**KIRKLEES METROPOLITAN COUNCIL
INVESTMENT & REGENERATION SERVICE**

DELEGATED DECISION TO DETERMINE PLANNING APPLICATIONS

Reference No:	2024/62/93117/E
Site Address:	8, York Place, Cleckheaton, BD19 3PA
Description:	Erection of two storey extension
Recommending Officer:	Faiza Bano

HOUSEHOLDER DELEGATED REPORT

DATE	INITIAL	DESCRIPTION
		PROPOSED EXTENSION
AT 8 YORK PLACE CLECKHEATON WEST YORKSHIRE BD19 3PA FOR MRS WKKI LISTER		
PLANNING DRAWING		
SCALE	1:100	1:1250
DATE	OCT 2024	DRAWN MB
MARTIN BUTLER AND ASSOCIATES		
DRG. NO	002

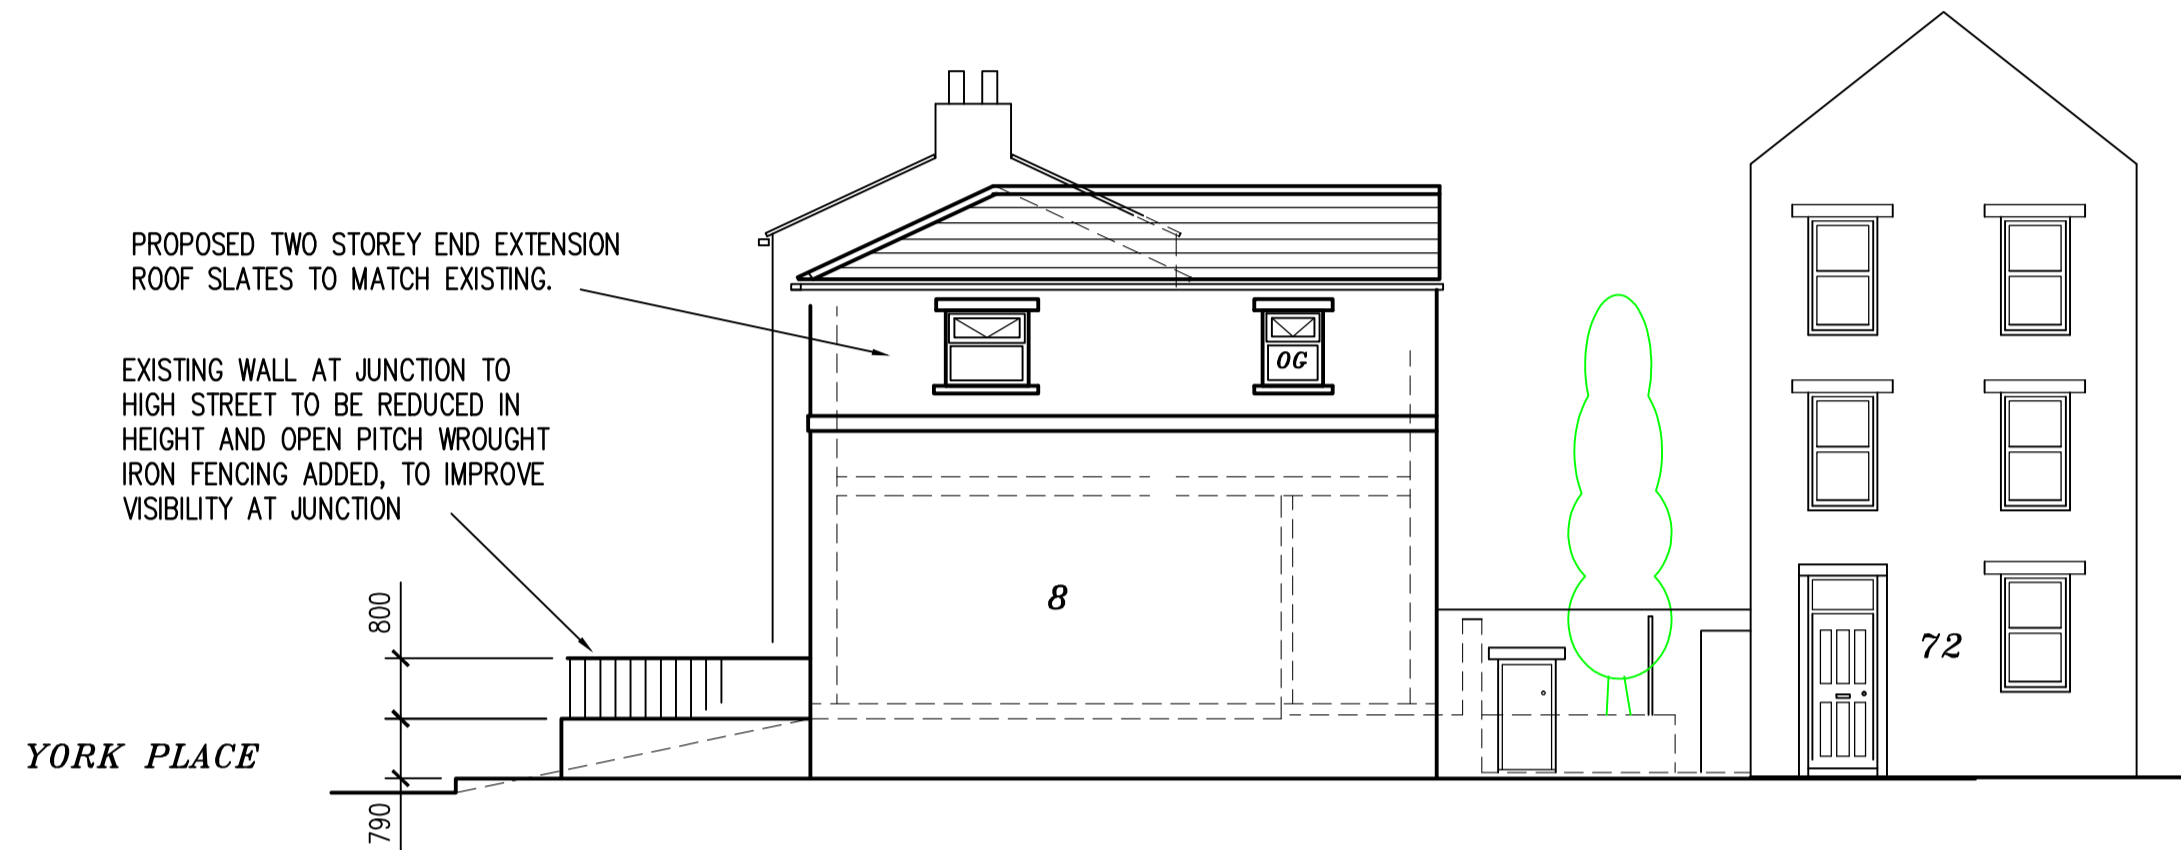
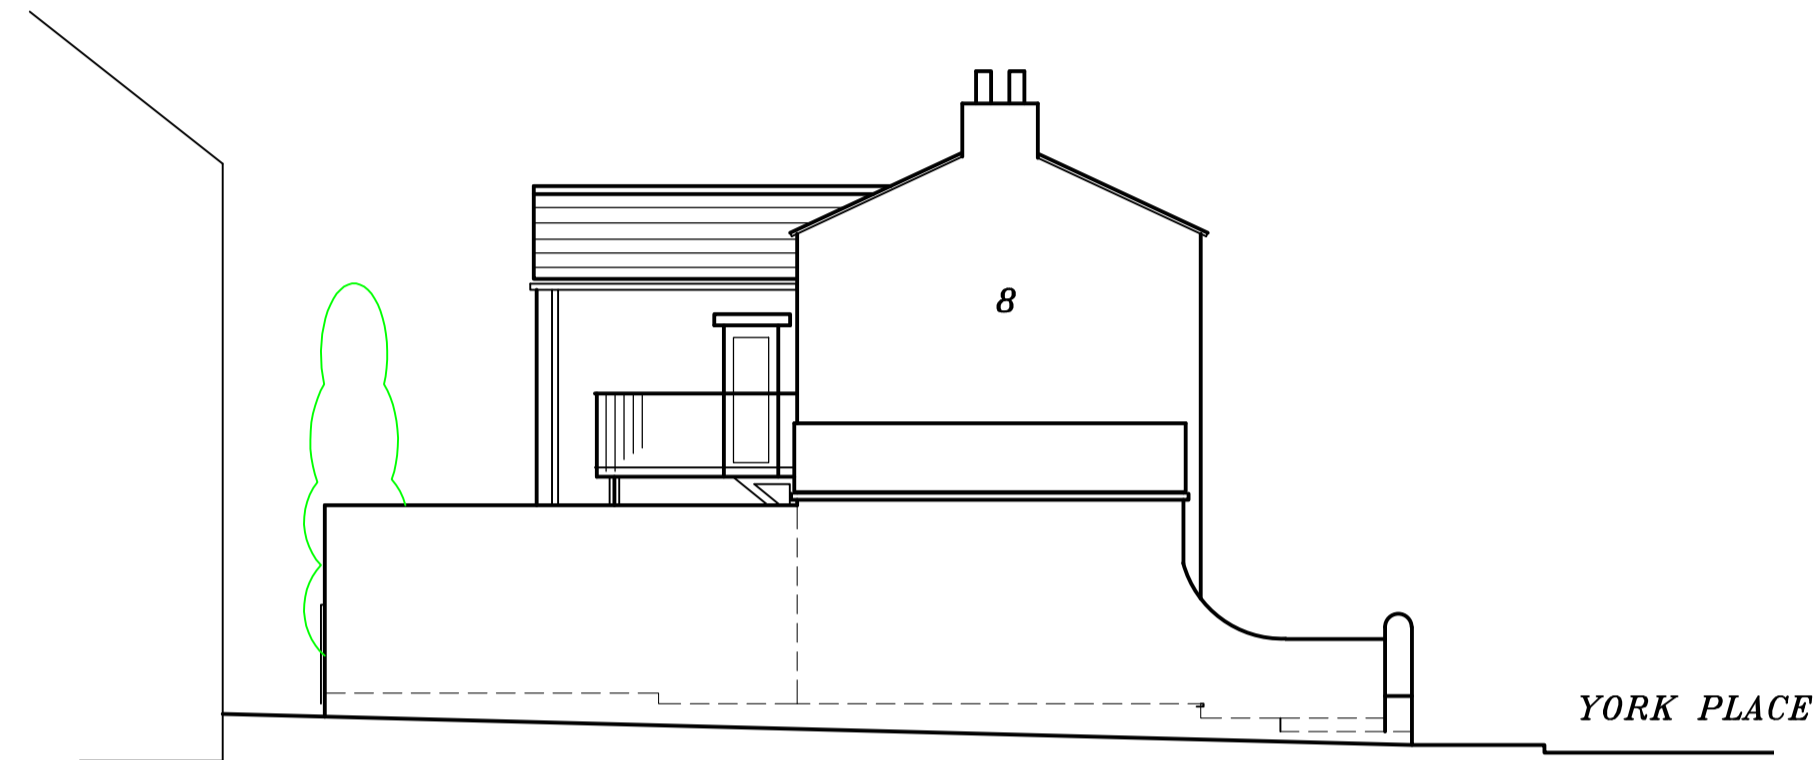
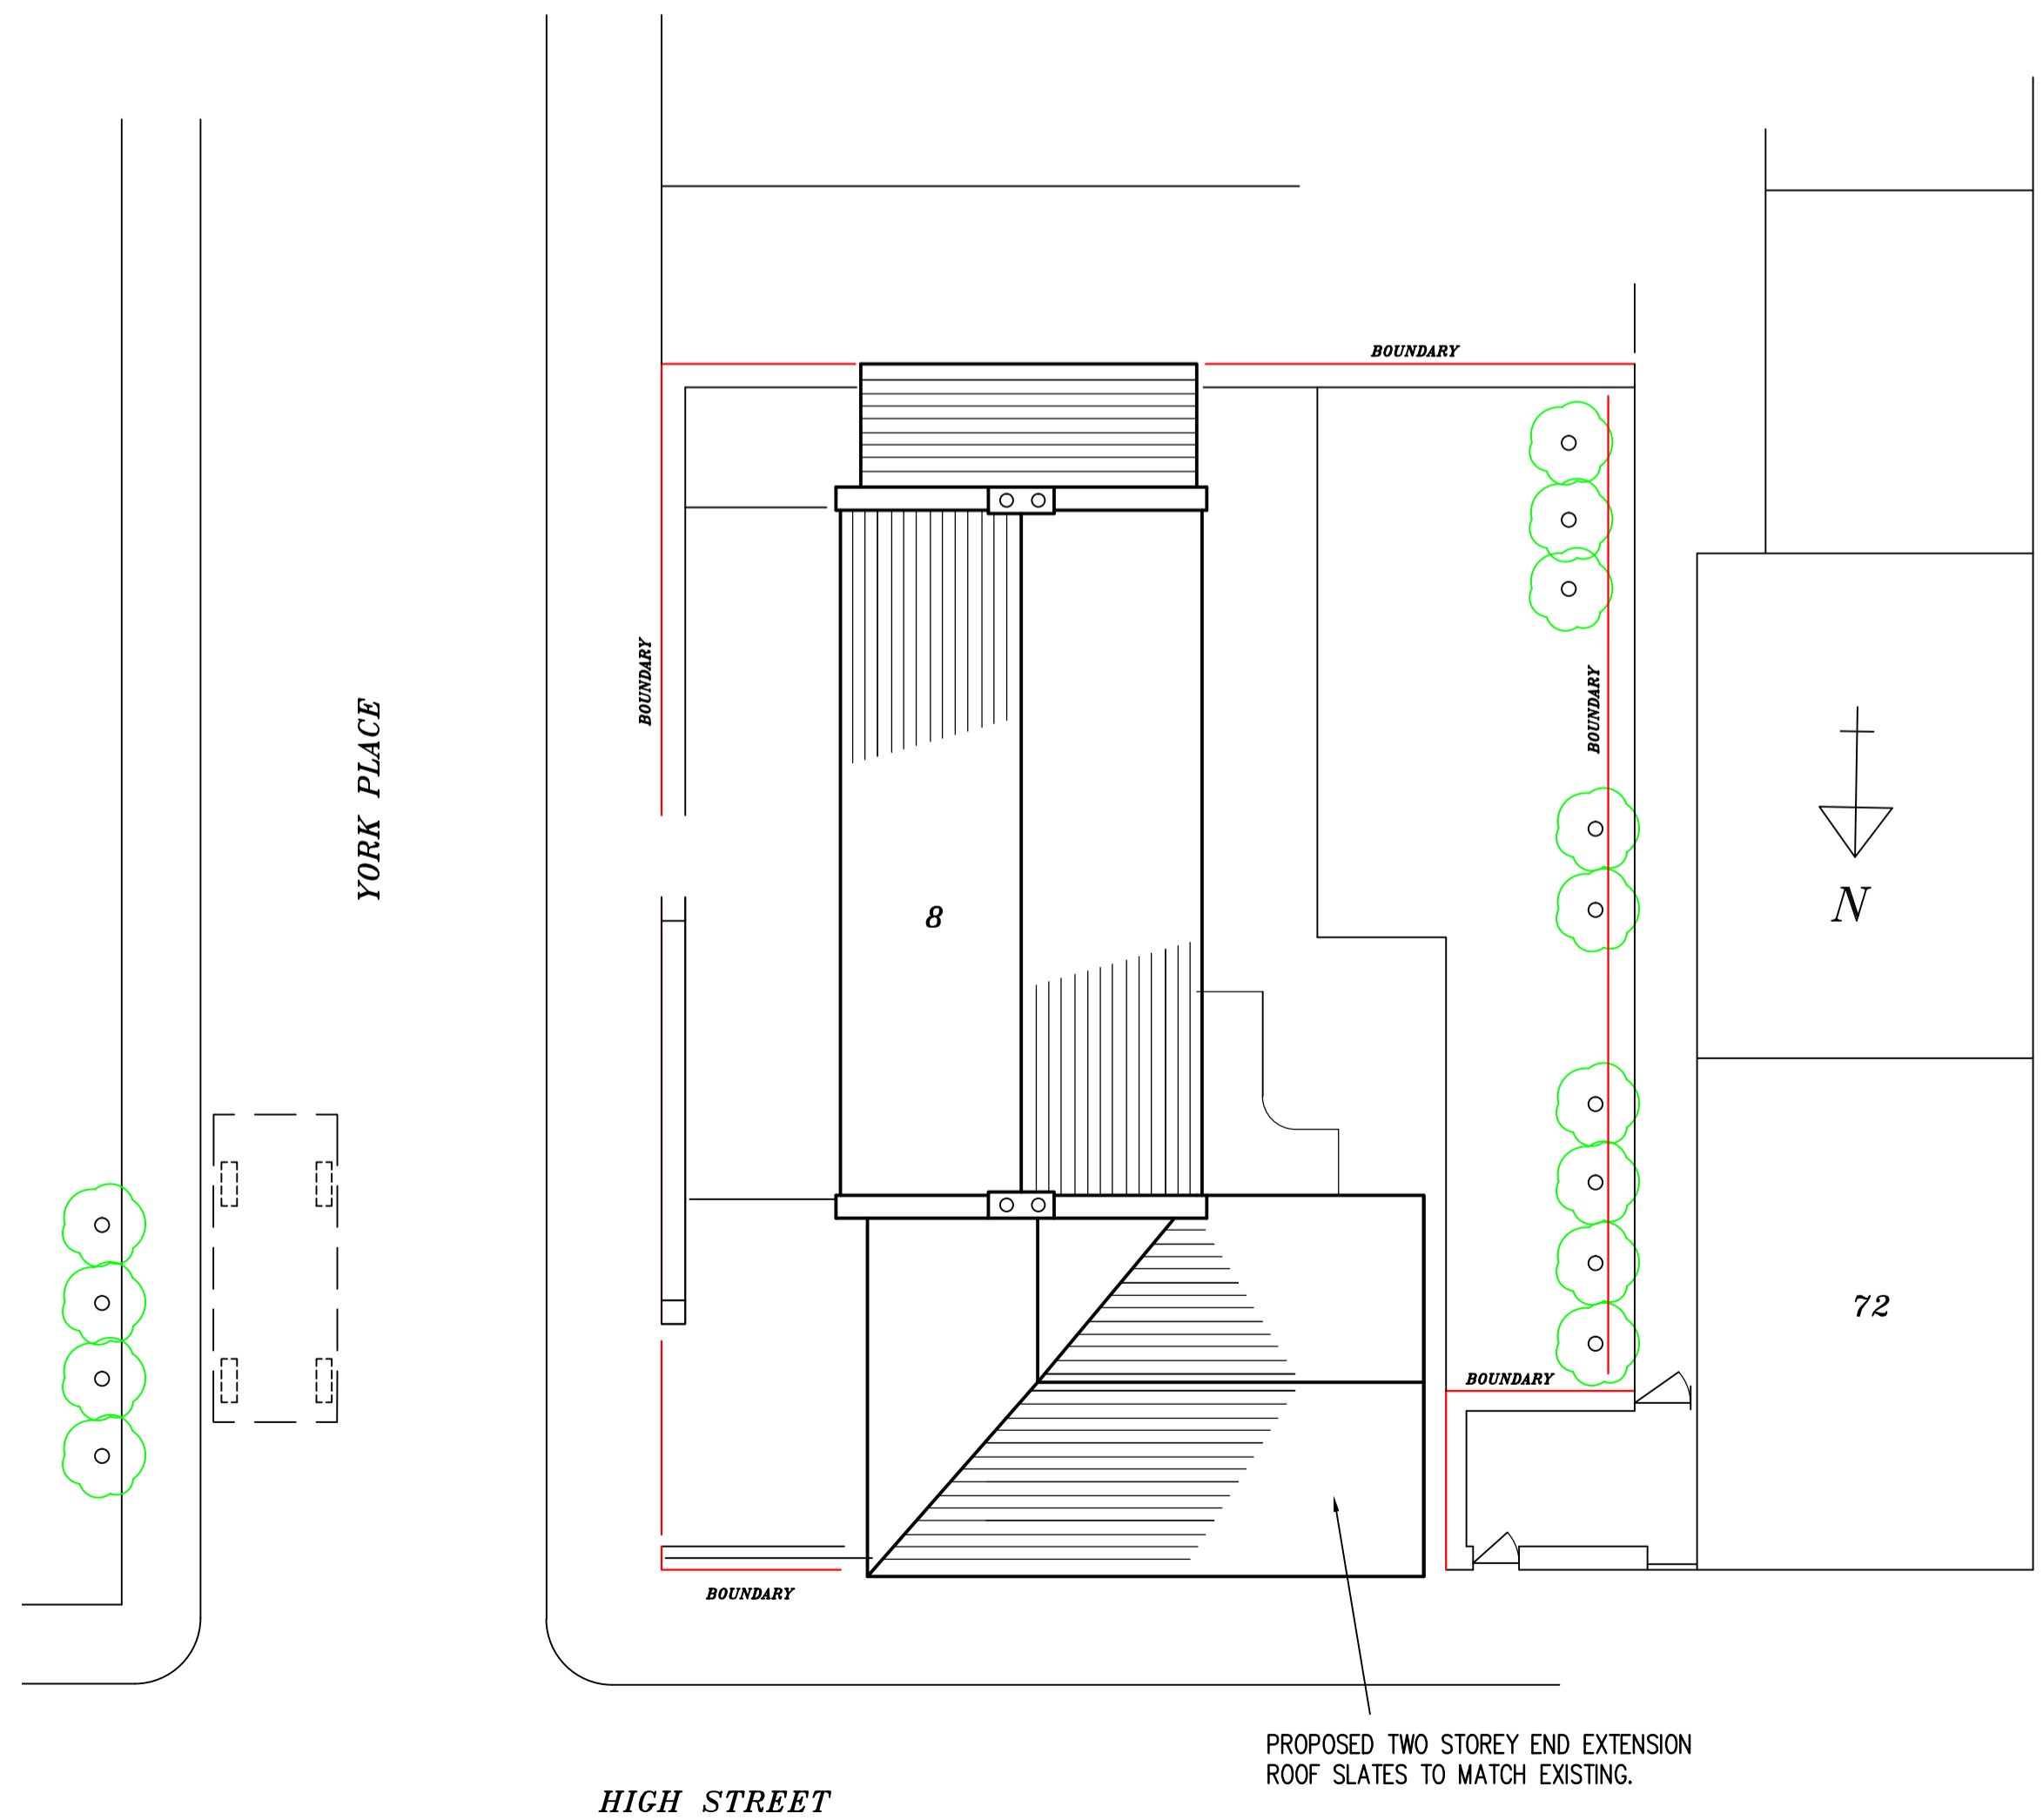
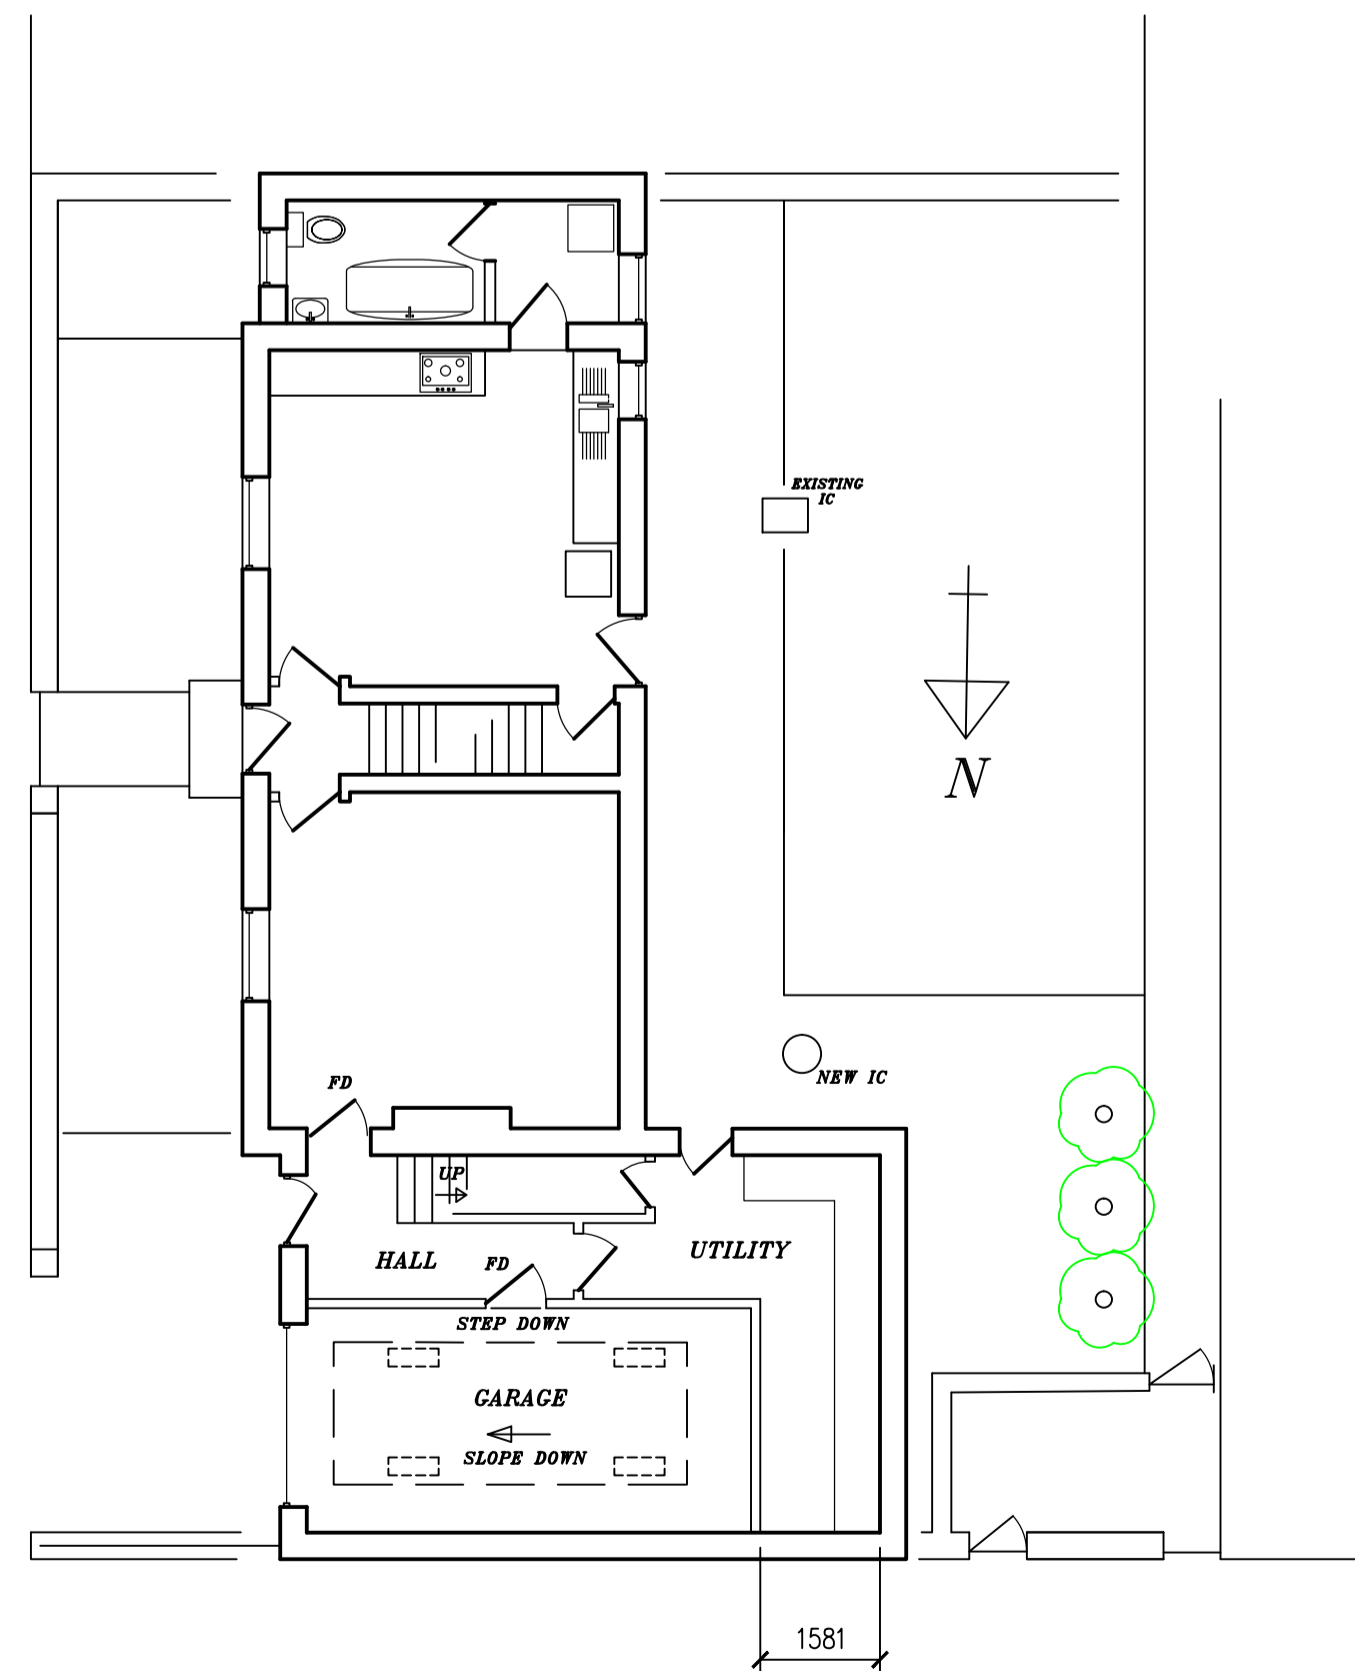
Two Storey Side Extensions Should:	<u>Yes - COMPLY</u>	<u>No - JUSTIFY</u>
not take up all or most of the space to the side of a house;		No – the proposed extension projects out by approximately 5 metres. The design and scale are in keeping with the character of the area. No significant adverse effects will occur on neighbouring properties due to the application site being a corner plot. The extension provides essential space and functionality. Considered acceptable.
maintain a 1 metre gap to the side boundary to ensure the building is not too close to a		No – the application site is detached and the proposed development will include and build above

neighbouring property; and		the garage which is located along the boundary. The side elevation of this property will be in line with 72 High Street.
be set back at least 500mm from the front wall of the house.		Set back 490mm from the front wall and set below the original ridge line - considered acceptable.

Balconies and roof terraces should be:	<u>Yes - COMPLY</u>	<u>No - JUSTIFY</u>
Positioned, and screened if required, so that they do not overlook neighbouring homes or gardens.	The proposed balcony will be positioned between the proposed two storey extension and northern corner of the existing dwelling. The rear boundary is screened by a very large hedge and the openings facing the rear of the application site from neighbouring properties are considered non-habitable. The positioning of the proposed balcony will not raise any concerns for privacy and overlook neighbouring homes.	
Sited away from locations that are sensitive to additional noise levels or disruption.	Yes – the extension is residential and will not be disproportionate to the site and neighbouring areas and is sited away from areas that are sensitive to additional noise levels or disruption. The balcony is located to the rear of the property on a slight slope overlooking the rear garden.

Roof style	<ul style="list-style-type: none"> • KDP 1 and 2 of the SPD • Policy LP24 Design (a), (c) and (d) of the KLP • Chapter 12 of the NPPF 	Hipped roof style to extensions. The two-storey side extension features a hipped roof. The roof style is acceptable as it is in-keeping with the original roof style of the host property.	✓
Window proportions	<ul style="list-style-type: none"> • KDP 1 and 2 of the SPD 	Modest size windows in extensions, which would	✓

In this application, the proposed development includes a side extension, which effectively addresses the previous visual amenity concern, specifically from the main road. The extension ensures that the balcony will not be visible from the road, thereby preserving the visual amenity of the area.

Furthermore, an assessment of the floor plans for properties at the rear reveals that the openings are for non-habitable rooms, specifically a stair landing and a bathroom. The bathroom window features frosted glass, which significantly reduces any potential privacy issues.
